RE Demolition of existing structures on-site & erection of 42 No. dwellings with access, parking, landscaping and associated works. This application is a departure from the development plan.

I am writing to you in connection with the above development following recent comments to discharge conditions 10, 11 and to confirm further details relating to condition 20. Following an email from our engineer, I copy their response below again to formally submit the information.

PBA Drawing No.	Revision
108.5009.503	G

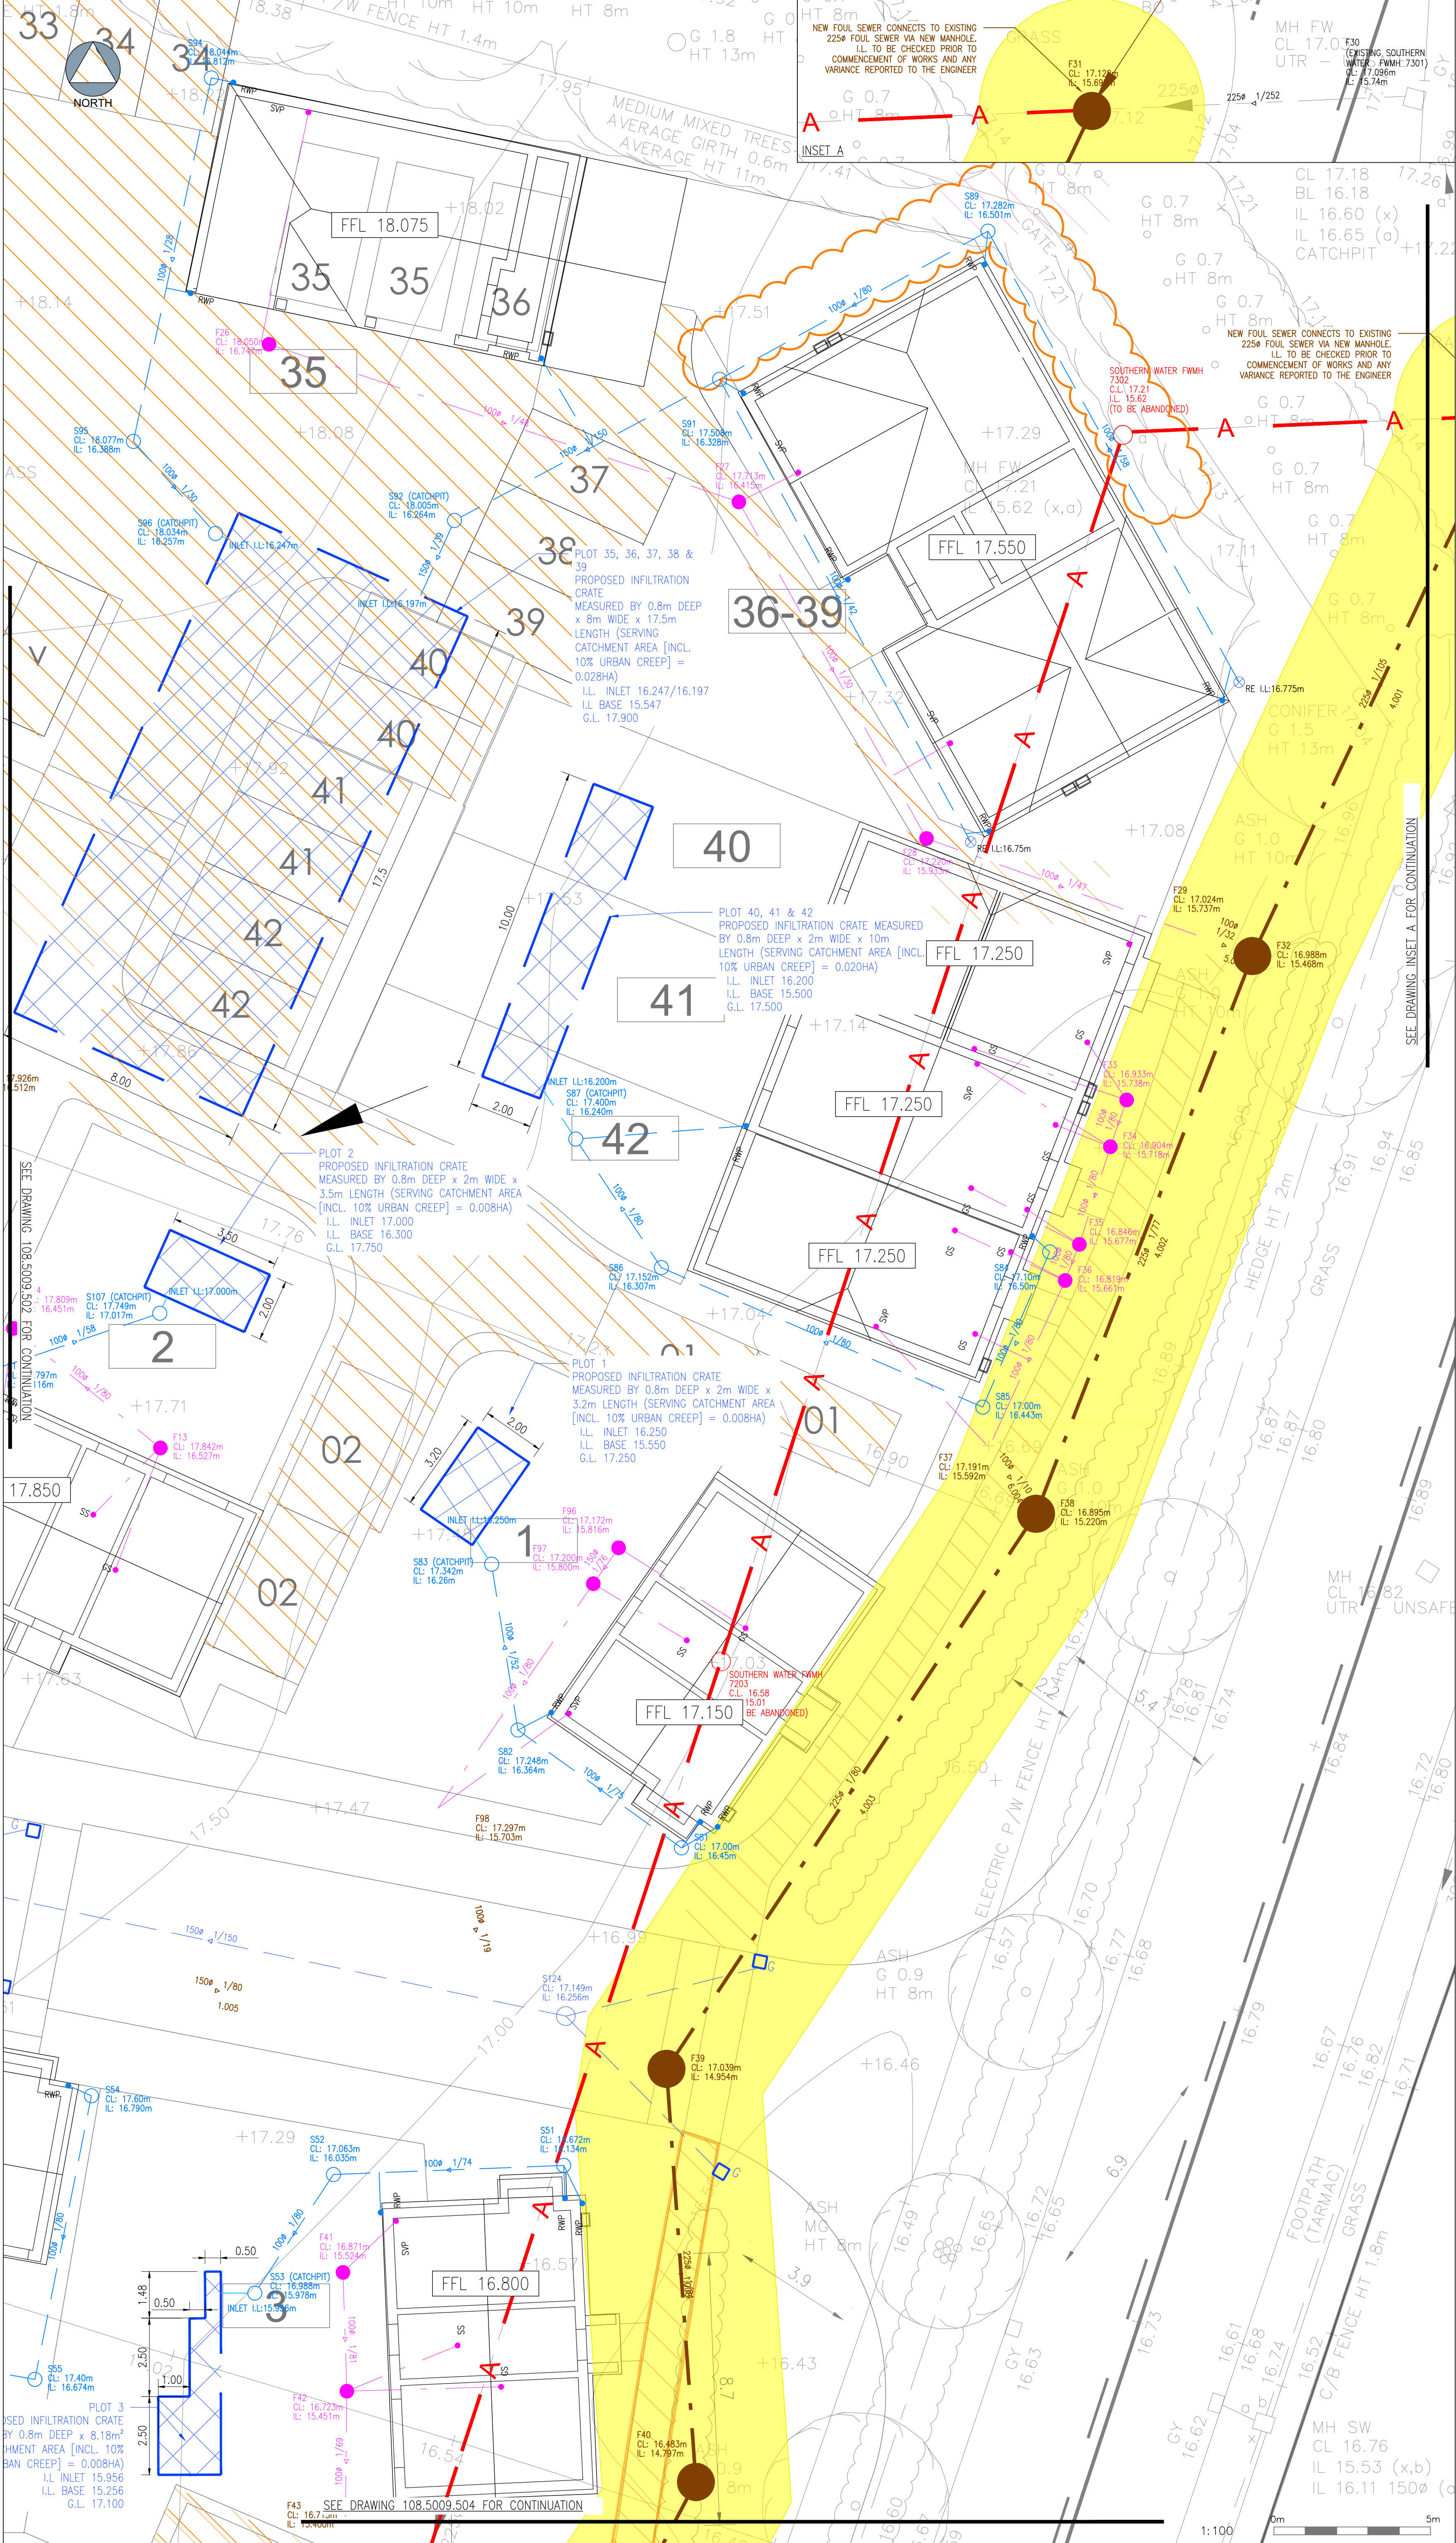
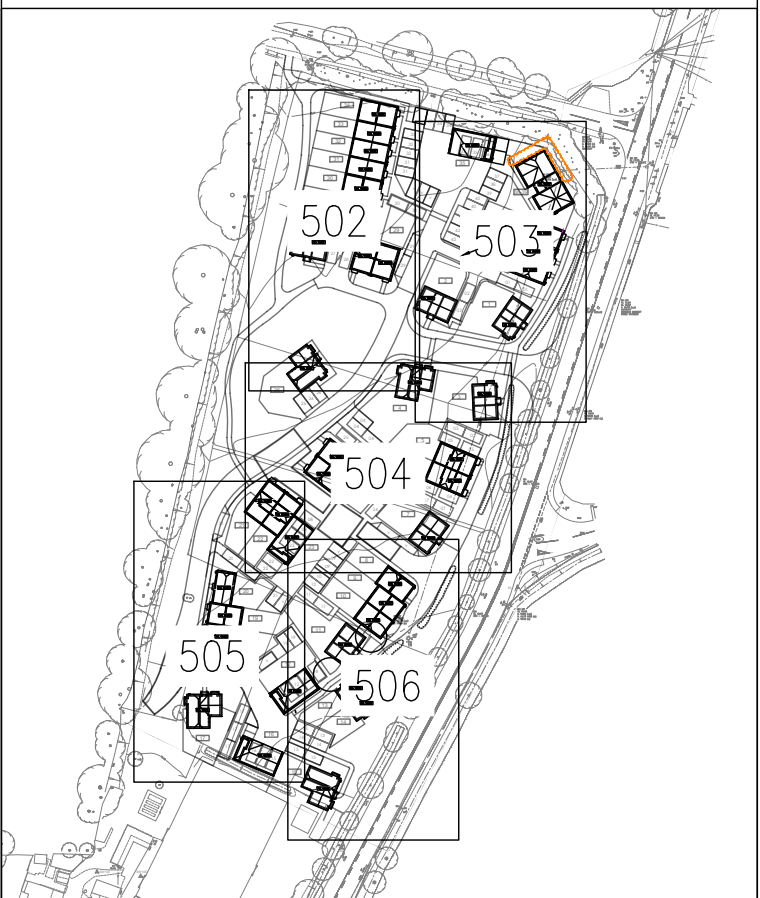
1. Catchpits must be provided upstream of all connections into soakaways. Please clearly show these on plan

2. Detailed drainage layout plans must show crate dimensions, i.e. length, width, depth, invert level, incoming invert level and cover level.

Catchpit annotation has now been added to drawings 502-506.

Drawings 502-506 updated to show crate dimensions.

Checked By RW	Checked Date 19.04.2021	Drawn By CLP	Drawn Date 19.04.2021
Client Drawing No. -	Scale 1:200	(AT A1 SIZE)	
PBA Drawing No. 108.5009.705	Revision G

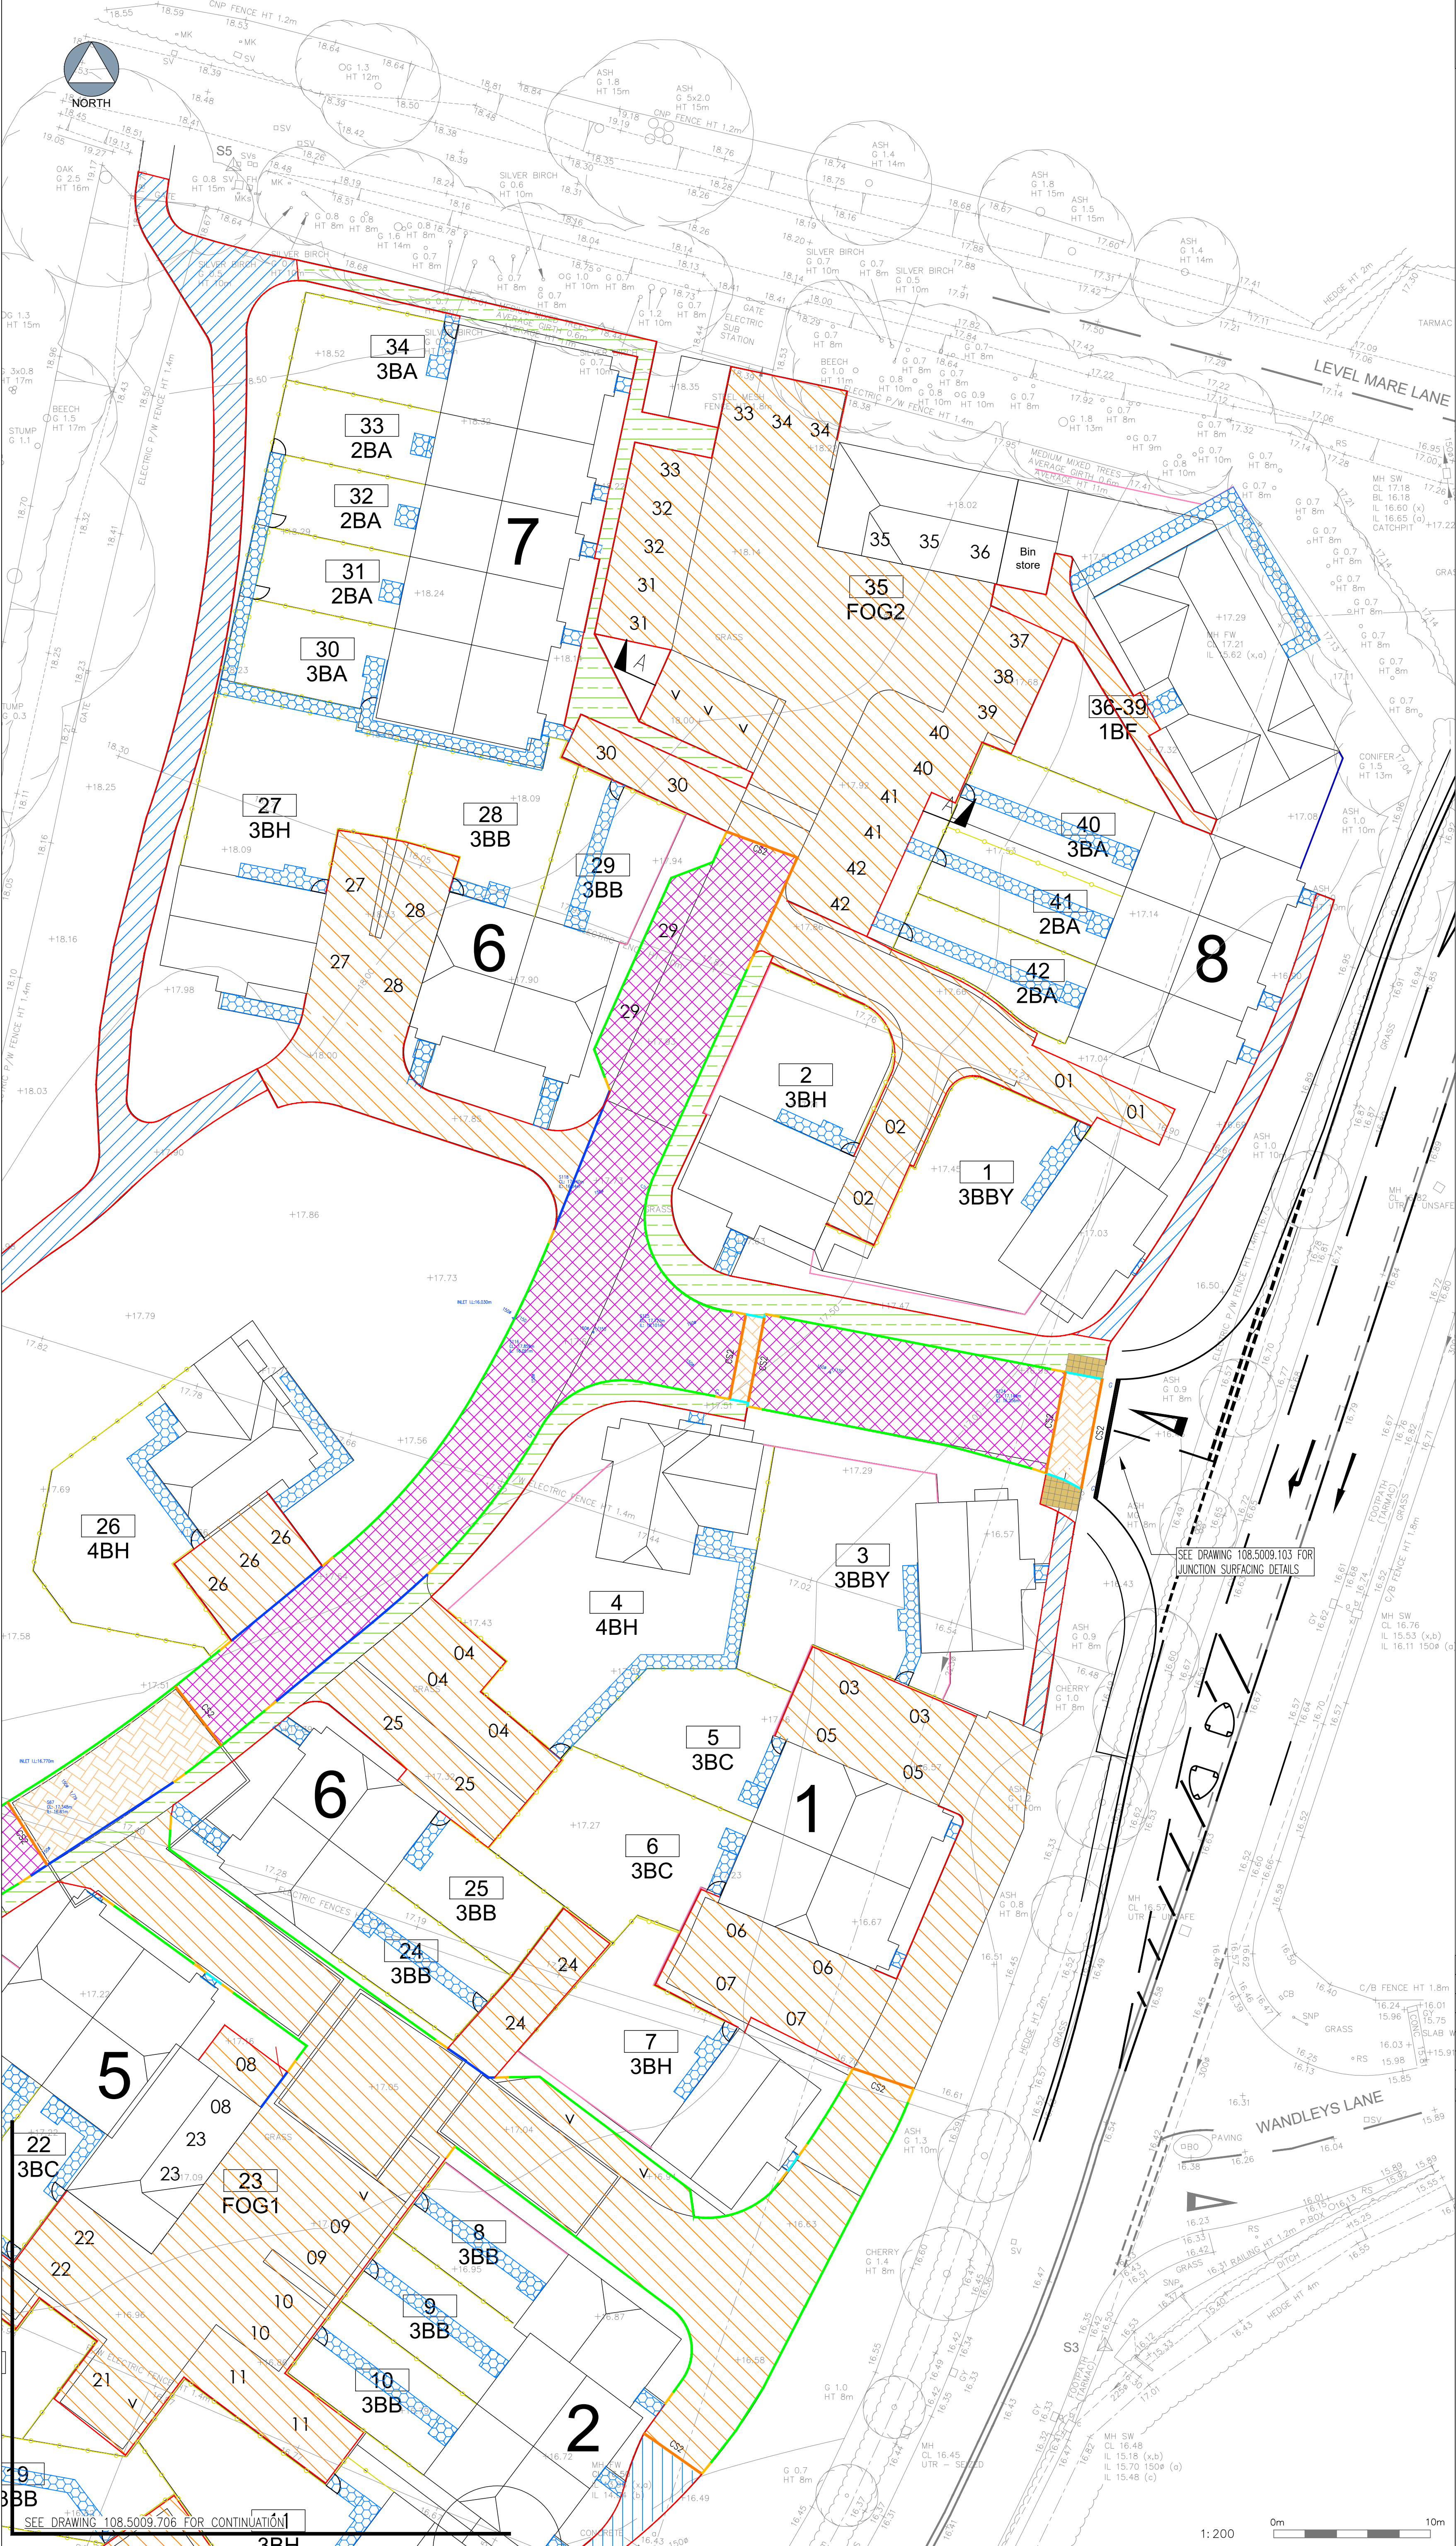
5. Finish and formation levels of permeable paving must be detailed.

The full details of the permeable paving are shown within drawing 751. Drawings 501-506 have been updated to show the construction of the permeable paving within the key. Please also refer to drawing 705 and 706 for full details on the external finishes. Drawings 704 and 703 have now been provided which detail formation levels.
